Application Ref:	2025/0223			 Ribble Valley Borough Council www.ribblevalley.gov.uk				
Date Inspected:	13/05/2025	Site Notice:	N/A					
Officer:	EP							
DELEGATED ITEM FILE REPORT:					APPROVAL

Development Description:	Proposed two-storey side extension to side.
Site Address/Location:	21 Park Avenue, Clitheroe BB7 2HP.

Drawing Title
Proposed Plans and Elevations for
Two Storey Side Extension

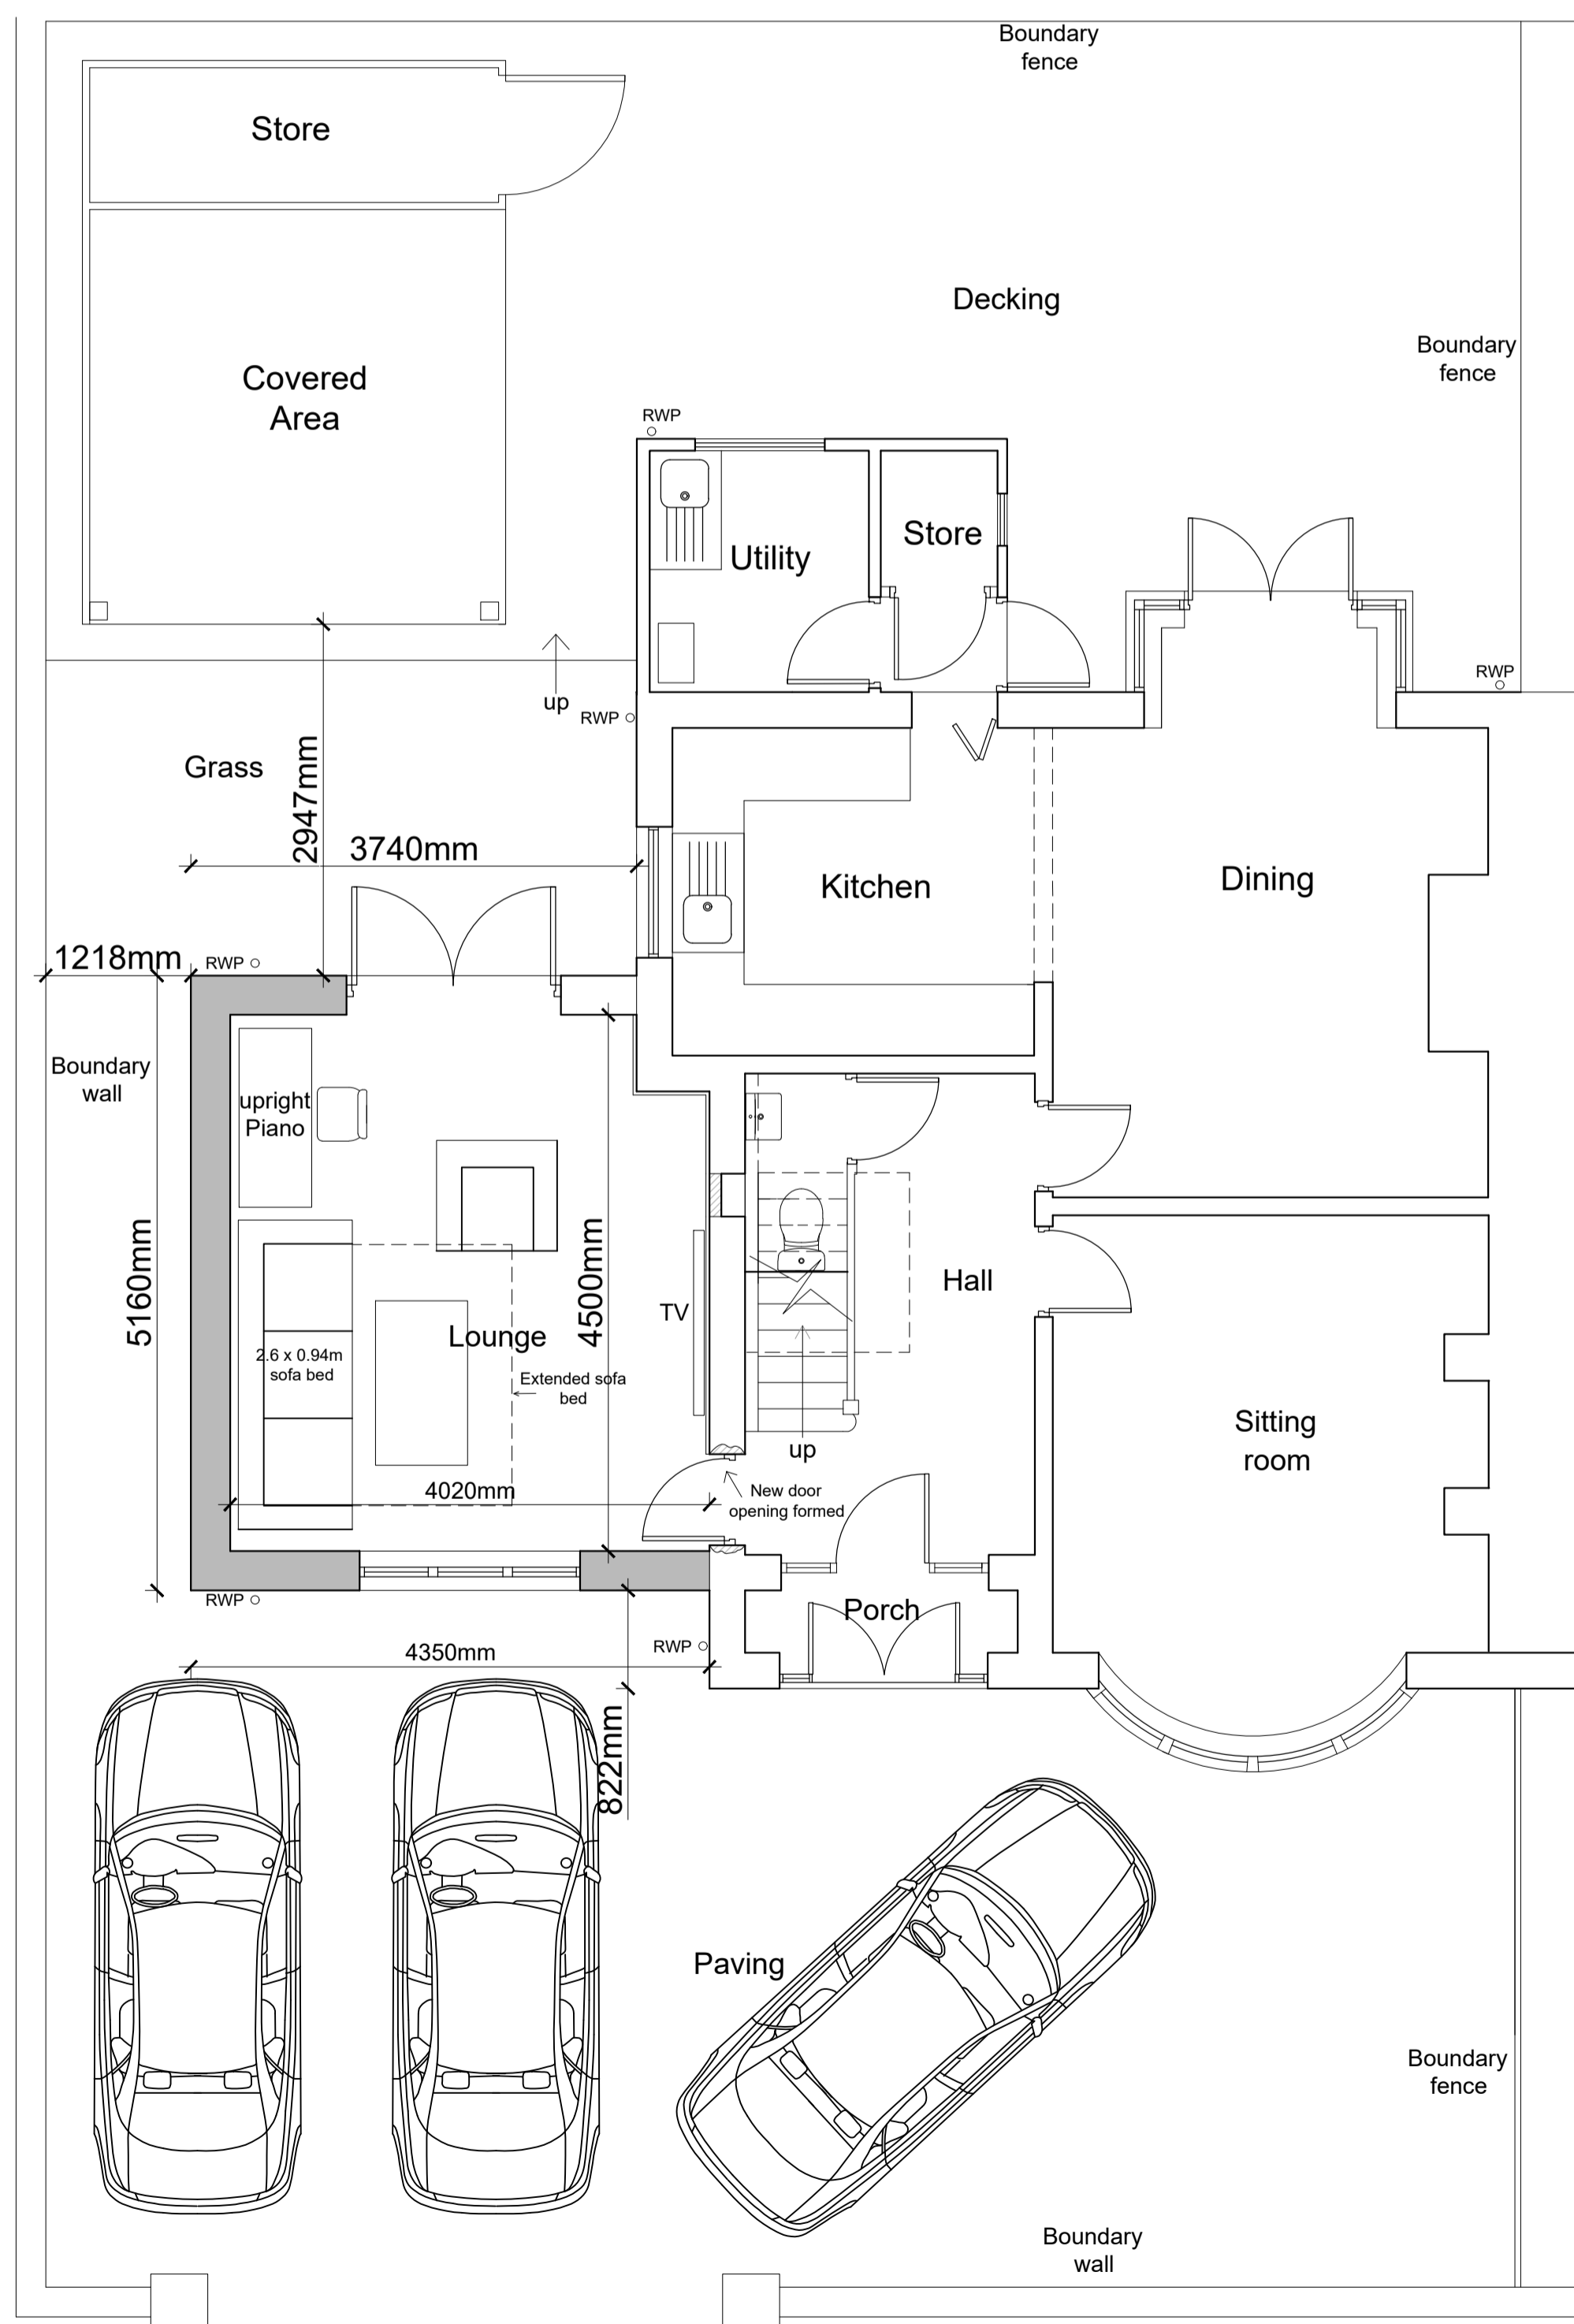
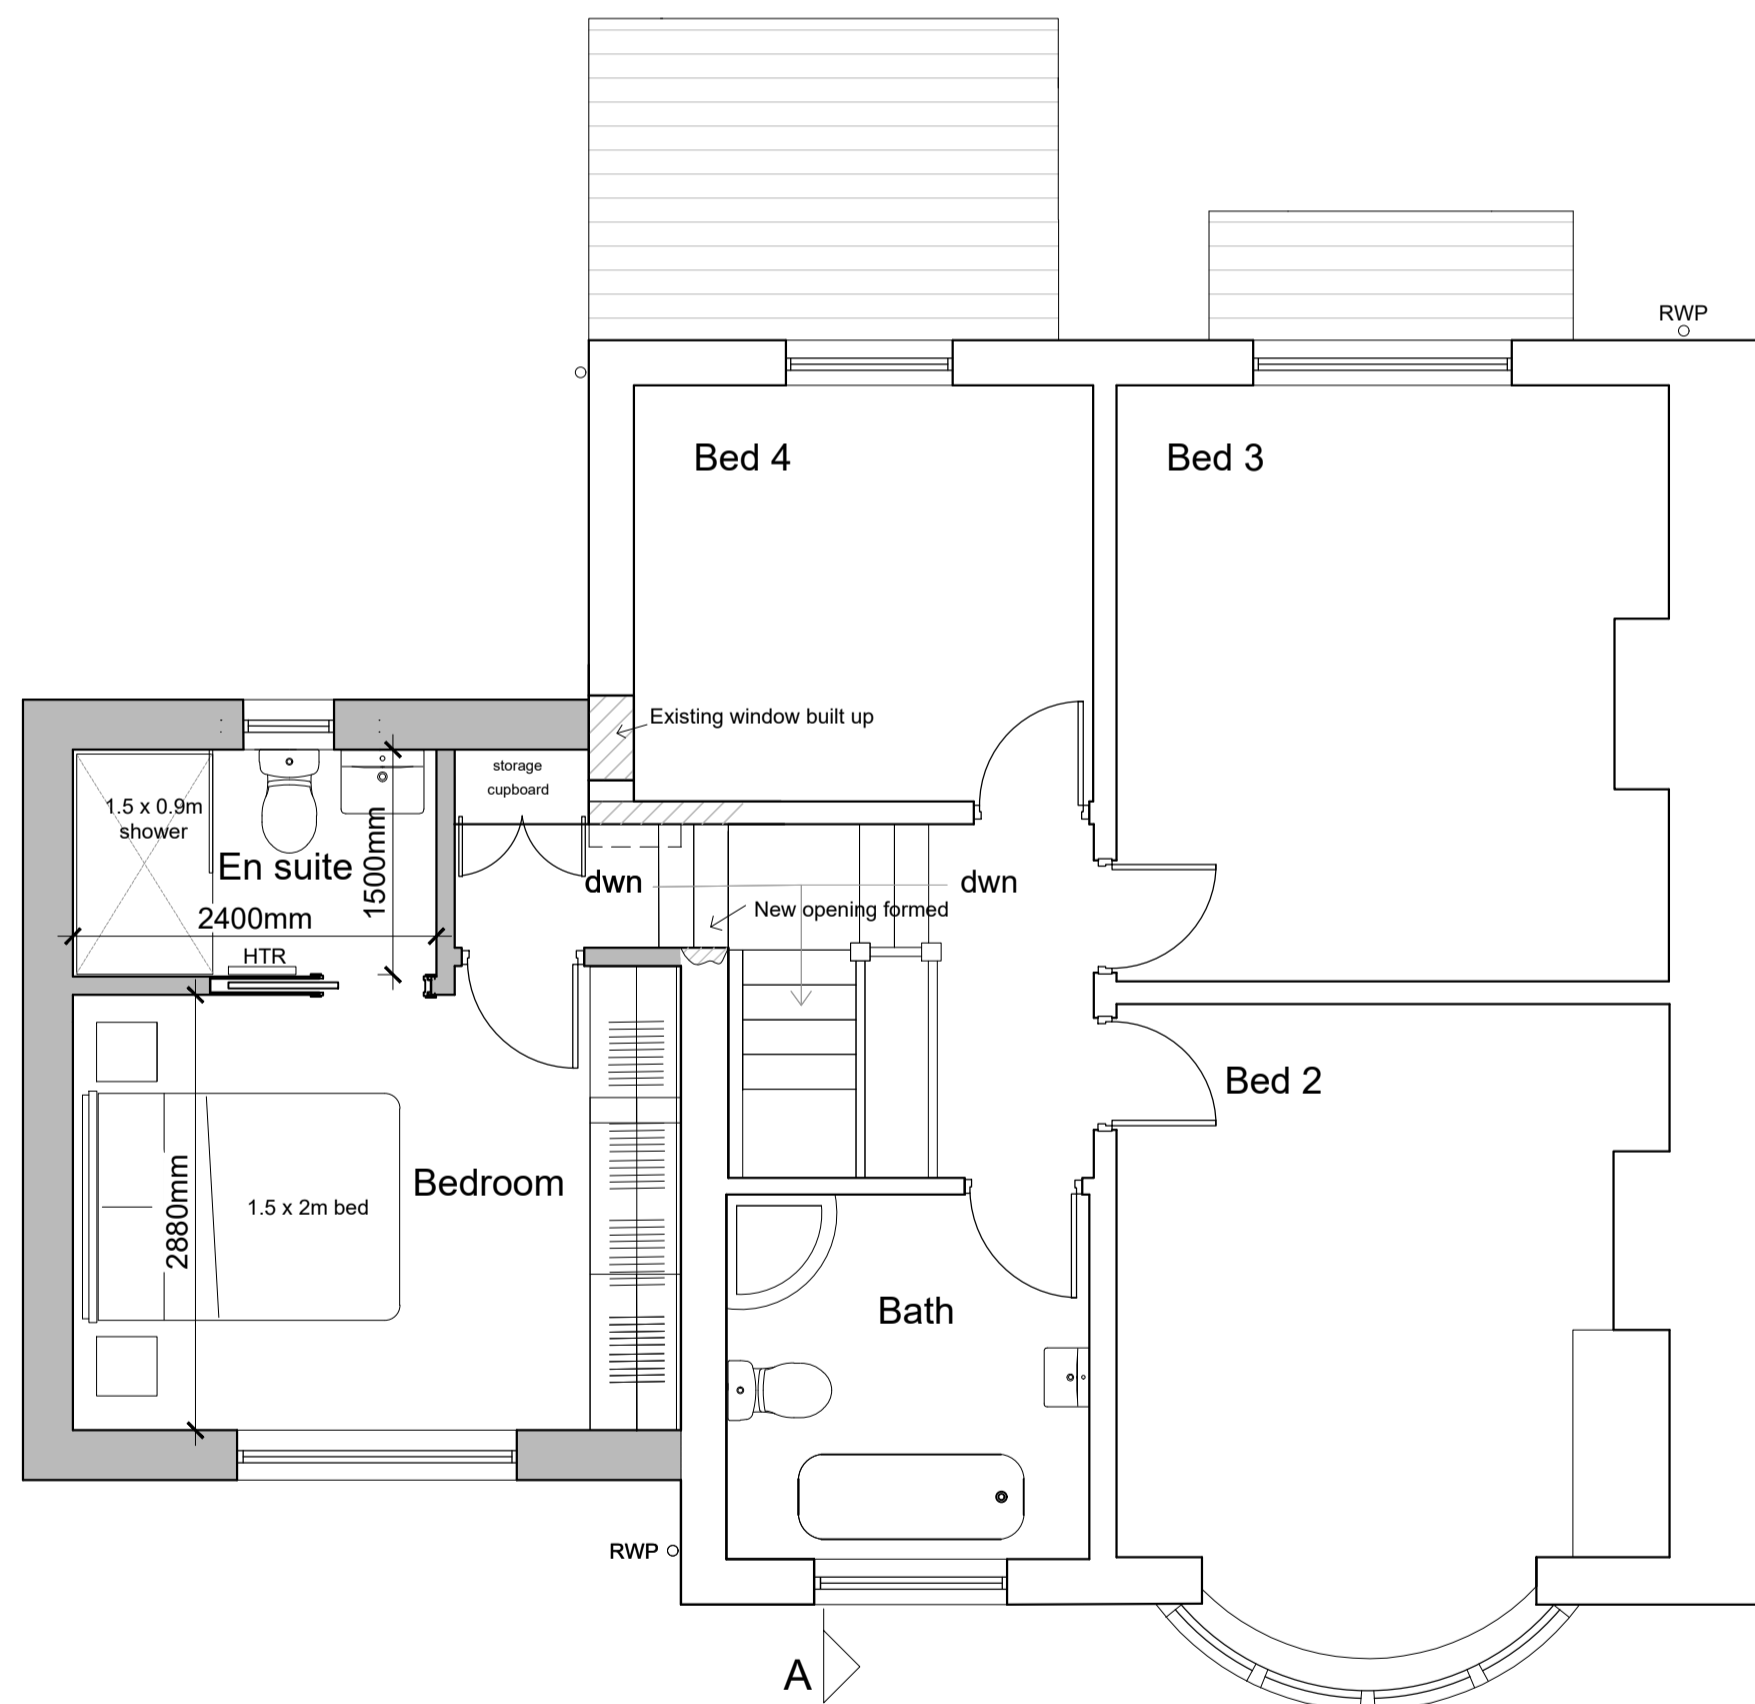
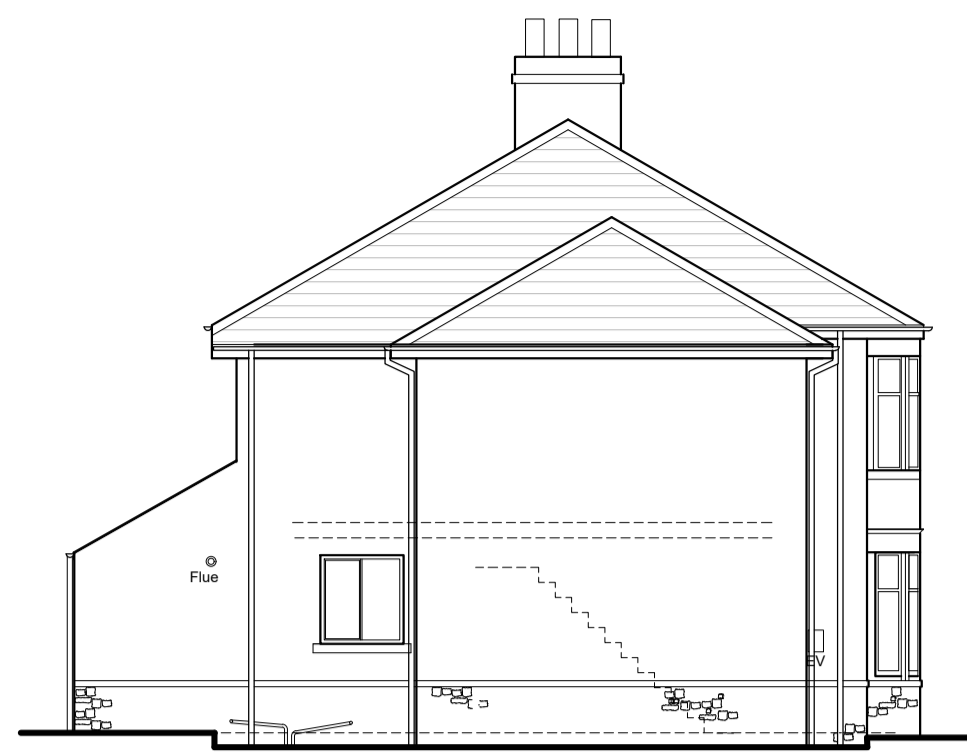
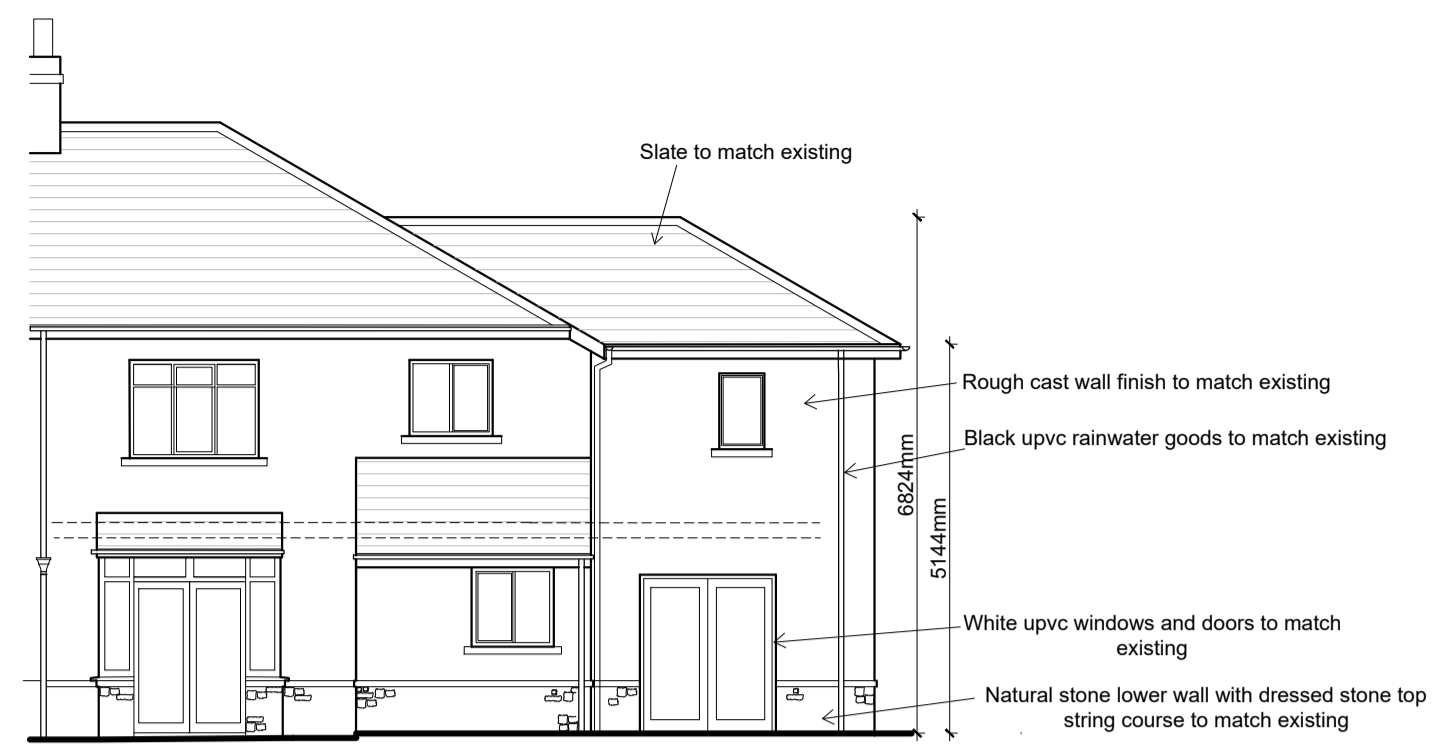
No.19 is located to the west of the application dwelling, where the proposed two-storey extension is to be sited. The extension will measure 5.1m in length and will project 1.22m from the shared boundary with No.19. No.19 has two window openings on its eastern side elevation; however, it is understood that these are secondary windows and not the only source of light to these rooms. In addition, the proposed extension does not project the entire length of the dwelling, with the existing dwelling being set well behind the principal building of No.19. As a result, the development will not inflict any significant loss of light to a degree that would warrant refusal.

There is no new window openings proposed in the side elevation of the dwelling, so there is no loss of privacy concerns in this respect. To the rear of the extension, there are glazed doors proposed at ground floor and a singular window opening at first floor. The ground floor opening will provide views solely of the applicant's rear garden. The first-floor window creates potential for overlooking into the rear private amenity space of the property to the rear (No.20 Hawthorne Place), this window will serve an ensuite, so it is expected that the window would be fitted with secure glazing. This will be secured via planning condition to protect the amenity of No.20.

The extension will measure 5.1m by 3.7m in length and width, with an eaves and ridge height of 5.1m and 6.8m respectively. The extension will feature set back from the principal building line of the dwelling by approximately 820mm with the ridge falling well below that of the existing dwelling. As a result, the proposed development will take an entirely subservient position to the host dwelling.

In respect to materials, the extension will be constructed using rough cast render to the elevation with a natural stone plinth, white uPVC windows and a slate roof. These materials are consistent with the existing dwelling, as well as properties in the vicinity. It is therefore considered the proposal will integrate sufficiently into the street scene without causing harm to the character of the area.

LCC Highways were consulted in relation to the proposal and initially requested a parking plan to demonstrate the dwelling can accommodate 3 off road parking spaces in line with parking standards. Subsequently, a plan was submitted, which demonstrates the drive is wide enough for 3 spaces, although said spaces are not comfortably useable given the width of the access from the highway. LCC requested further detail demonstrating that the spaces can be utilised. However, given the location of the dwelling in a sustainable position close to town centre amenities, the plan provided demonstrating at least two useable spaces can be provided is considered sufficient in this instance.
